14 May 2021

## **RE: Submission on State Significant Development Application: SSD-10464 – 50-52 Phillip Street, Sydney**

This submission has been prepared by Perpetual Trustee Company Limited (**Dexus**) and Lendlease Funds Management Limited (**Lendlease**), the property owners of the land recognised as One Farrer Place, Sydney (**the 'asset'**), in relation to the proposed Concept (Stage 1) State Significant Development Application (**SSD DA**) at 50-52 Phillip Street, Sydney (**SSD-10464**).

PROPOSED ENVELOPE - NORTH ELEVATION - NORTH PHILLIP LANE ELEVATION

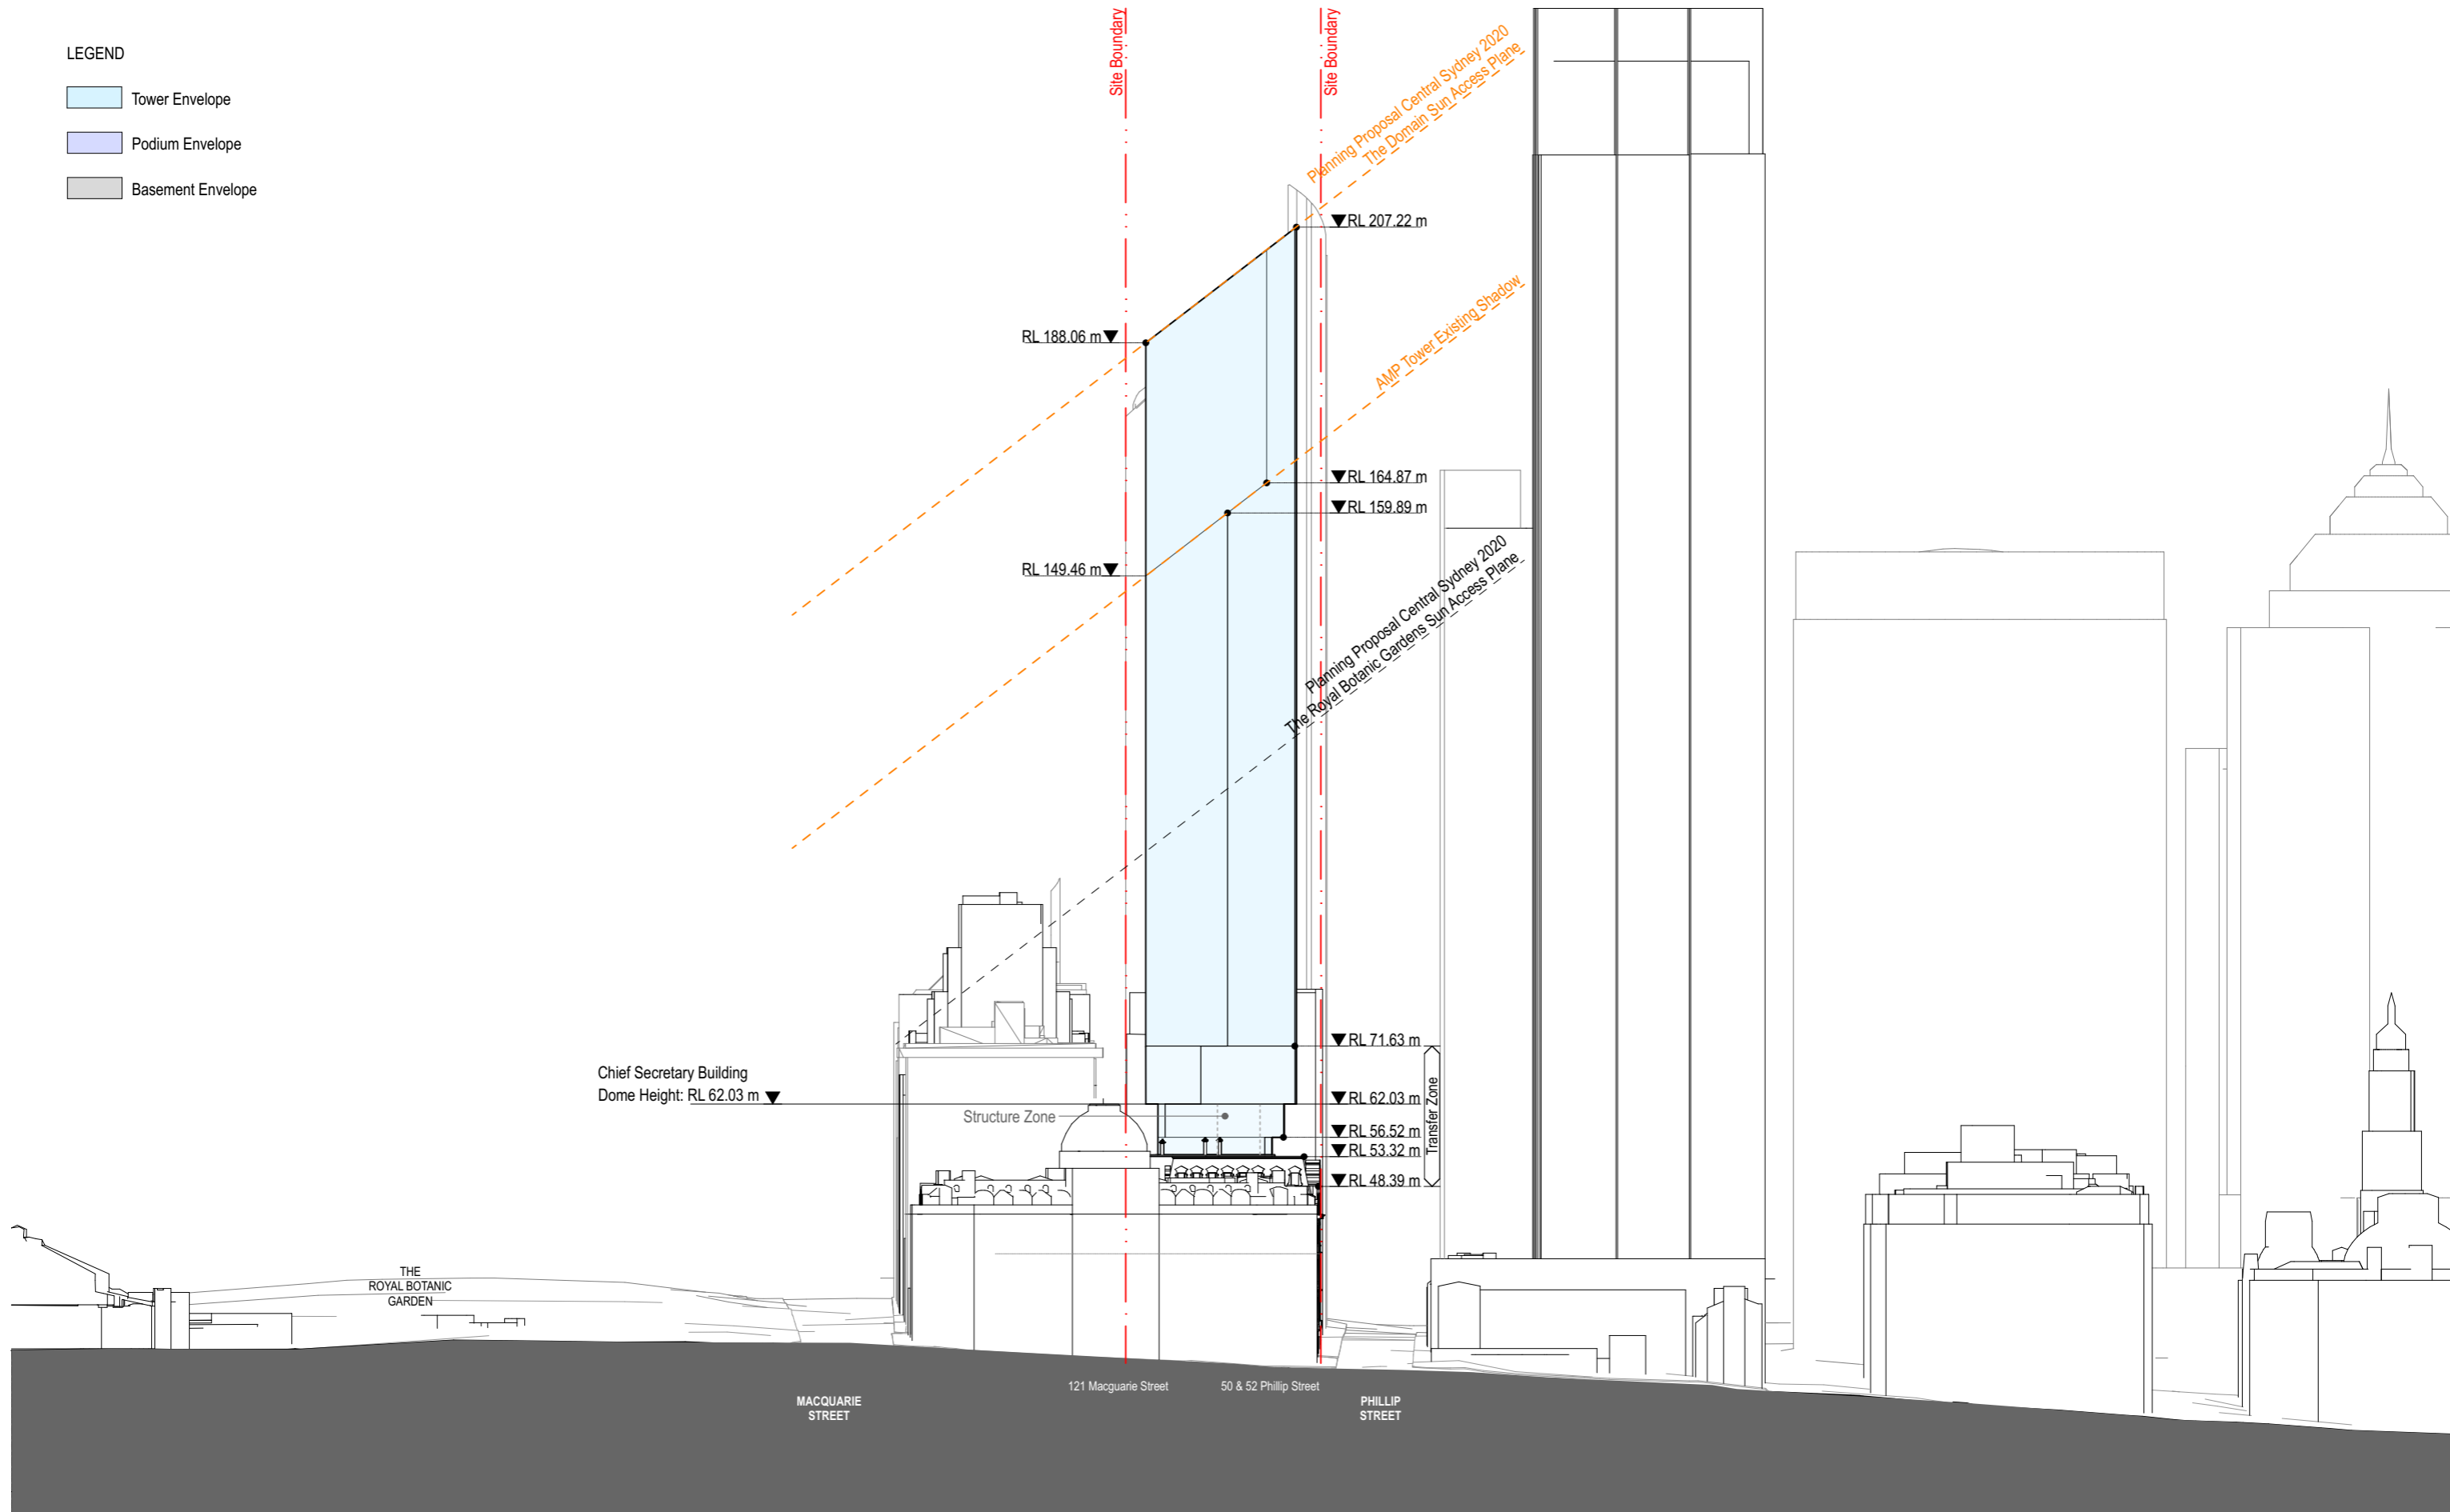
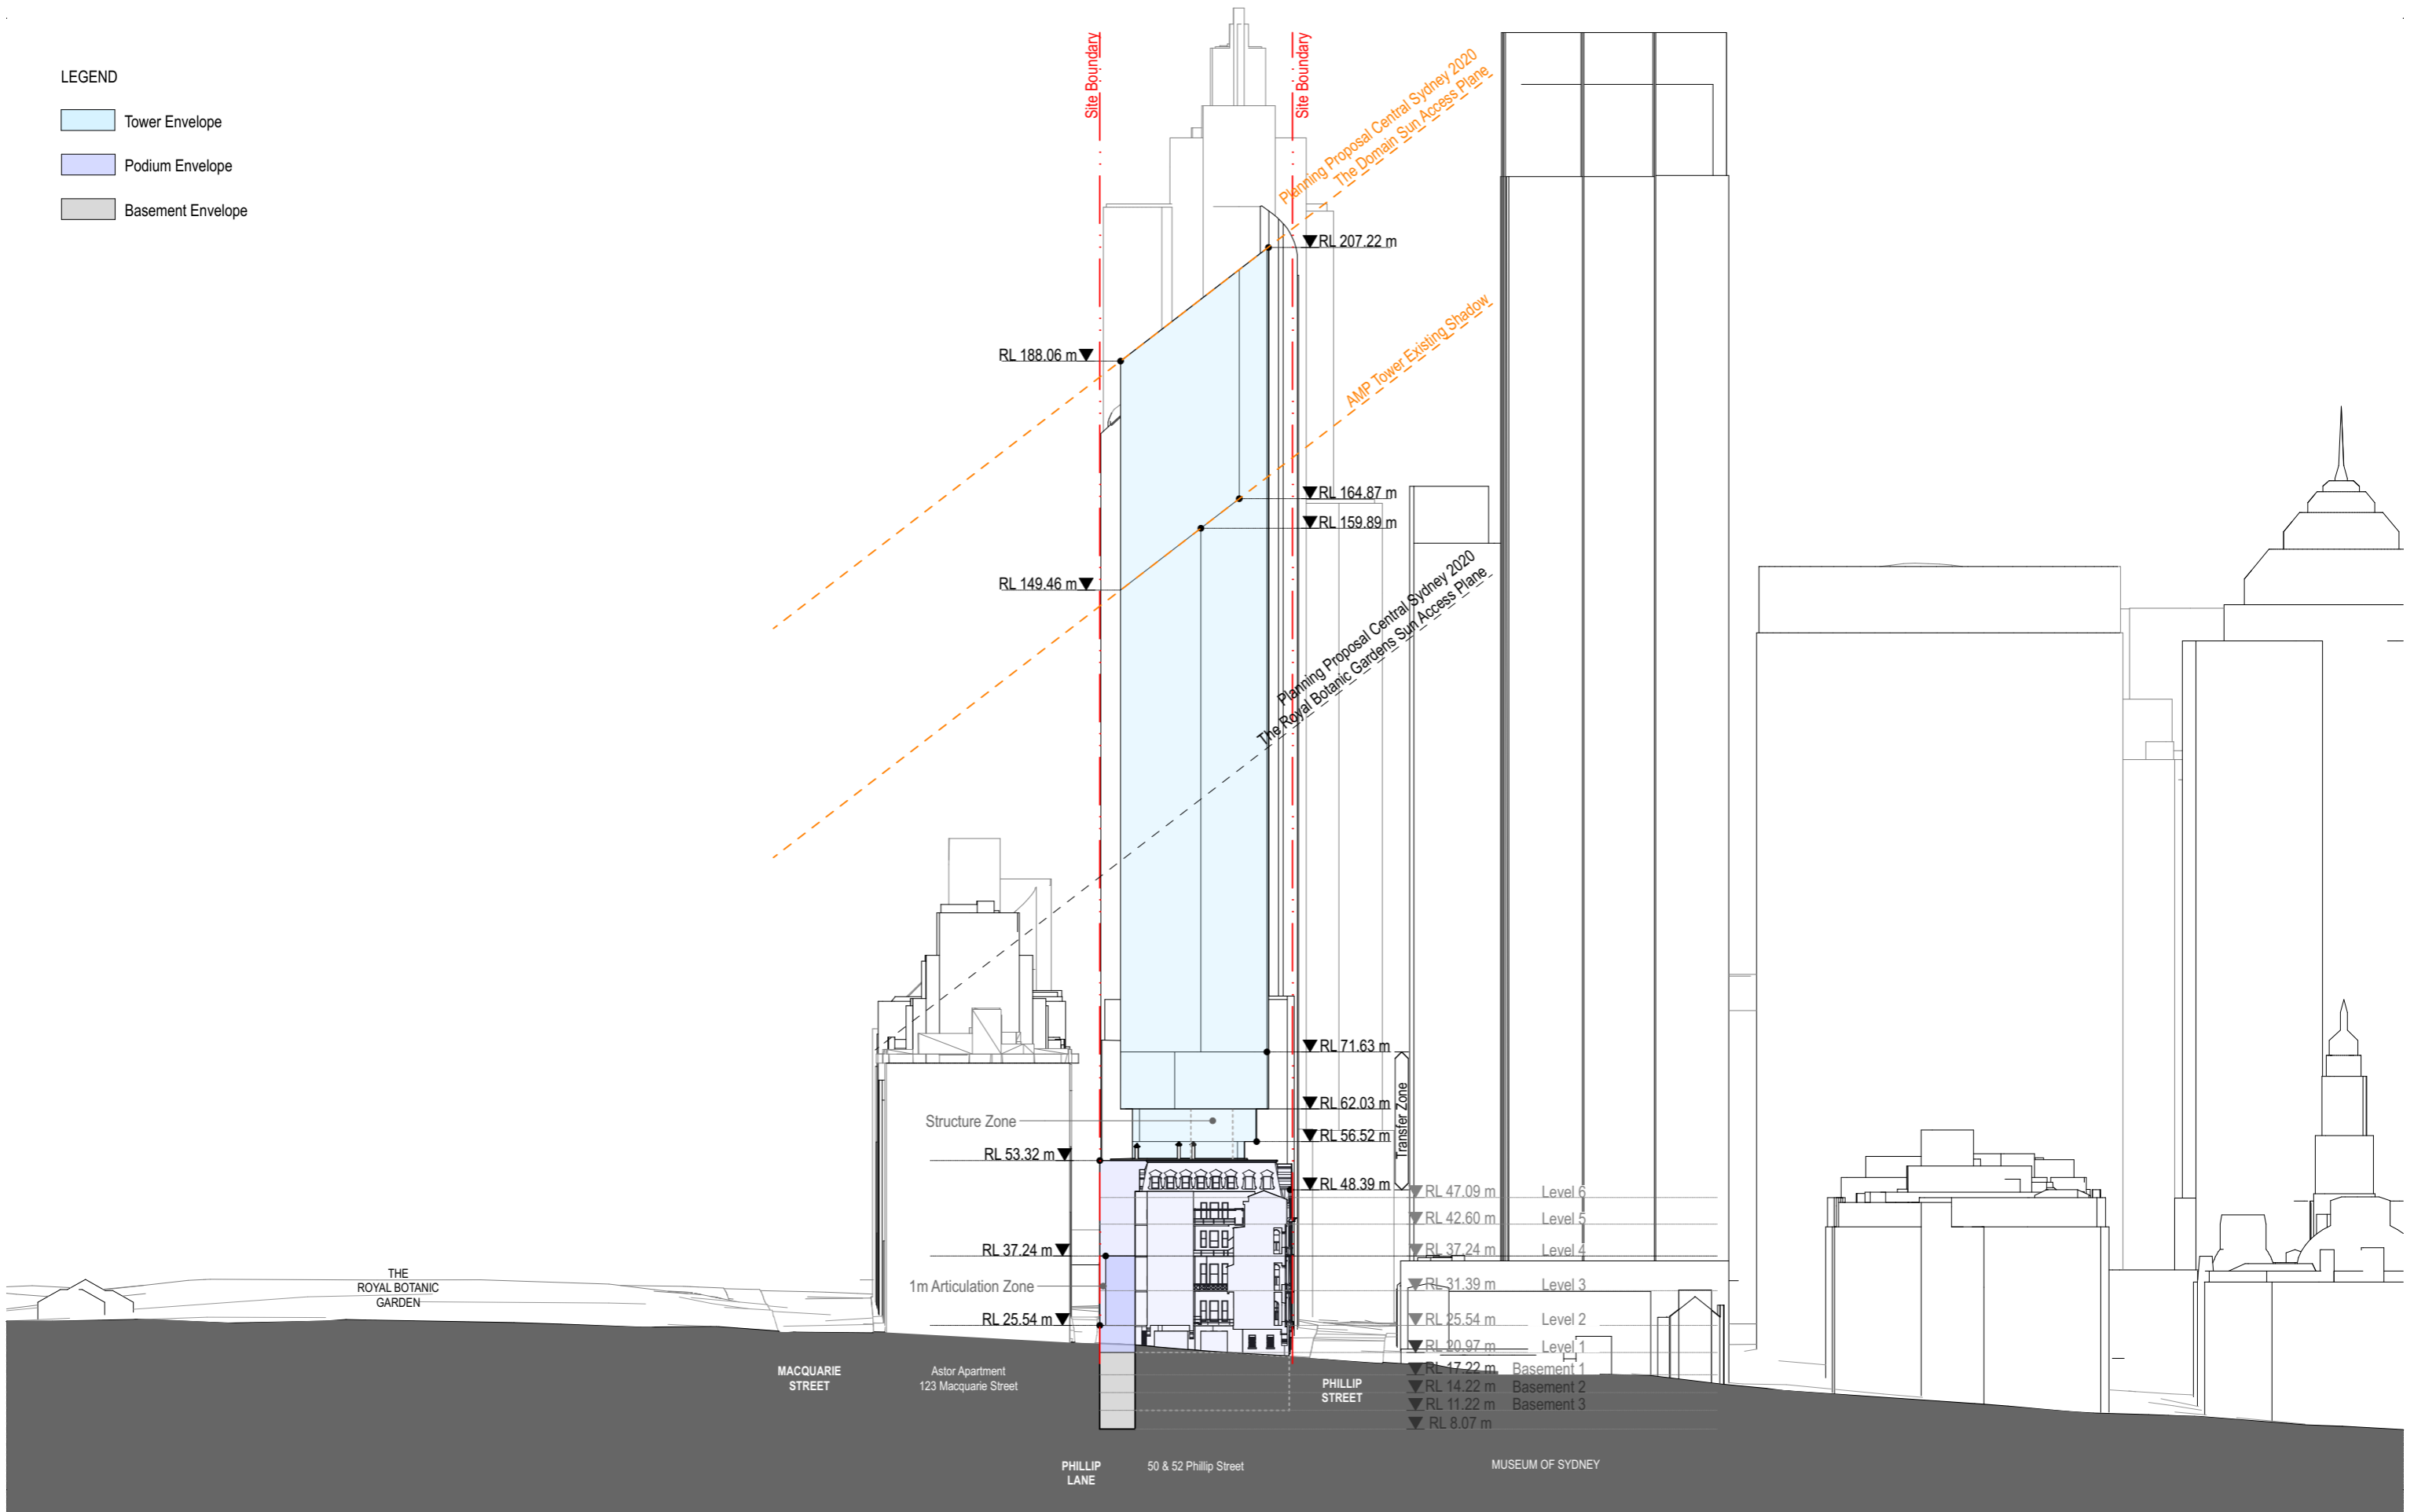
The proposed building envelope height exceeds both the Domain 7 SAP and Royal Botanical Gardens 8 SAP under the SLEP. The proposal seeks to justify this exceedance by utilising the modified SAPs for The Domain and Botanical Gardens under the Central Sydney Planning Proposal 2020 (**CSPP 2020**), notwithstanding the fact that the proposal still exceeds the modified Royal Botanical Gardens SAP (refer figure below).

It is noted that non-compliance with the SAP (i.e. height) controls could result in significant view sharing, daylight access and overshadowing impacts to our site which may cause adverse amenity impacts to existing tenants and site visitors. **We request that the building height is further investigated to address adverse amenity impacts to our site and improve daylight access and overshadowing.**

2.7 Setback Controls
 Sydney DCP 2012 Setback Control

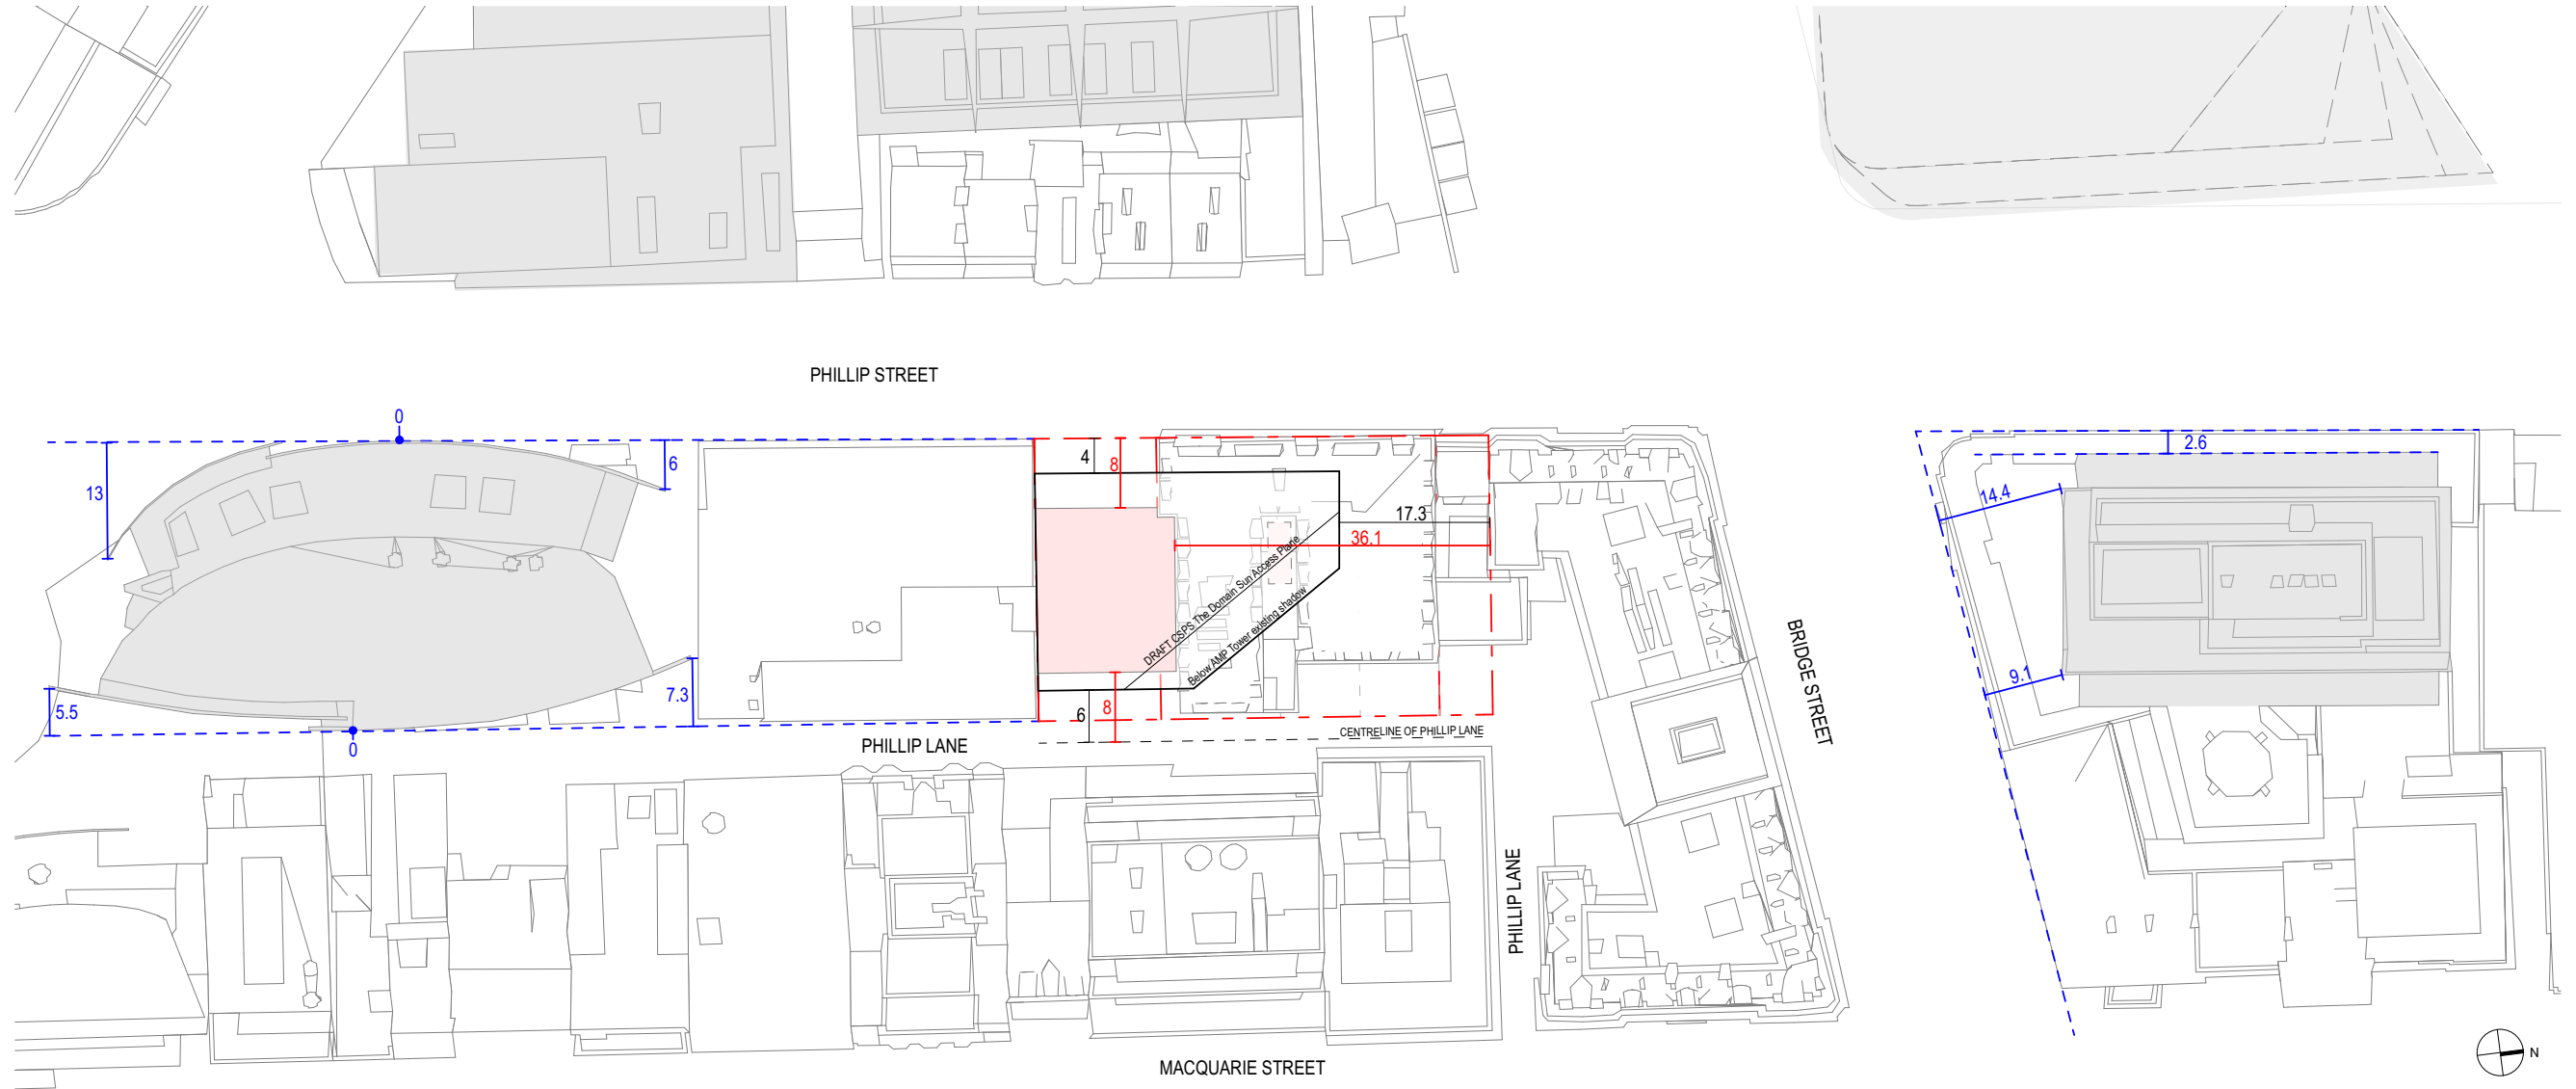
Section 5 of the SDCP includes specific controls relating to Central Sydney in which the SSD site is sited. An assessment of the proposal has highlighted that the proposal seeks to vary the setback requirements, most notably in relation to our site, is the variation to the Phillip Street 8 metre weighted average front setback (minimum 6 metres) (refer figure below).

We submit that the proposed non-compliant Phillip Street setback could result in adverse impacts on the amenity of our asset with regards to reducing our daylight and outlook, as well as impacting upon our view sharing, particularly our current unencumbered views to and from Sydney Harbour (towards the north and north-east).

**We request that the proposed Phillip Street setback is investigated further to mitigate adverse impacts to One Farrer Place, particularly regarding improving daylight/solar access and view outlook.**
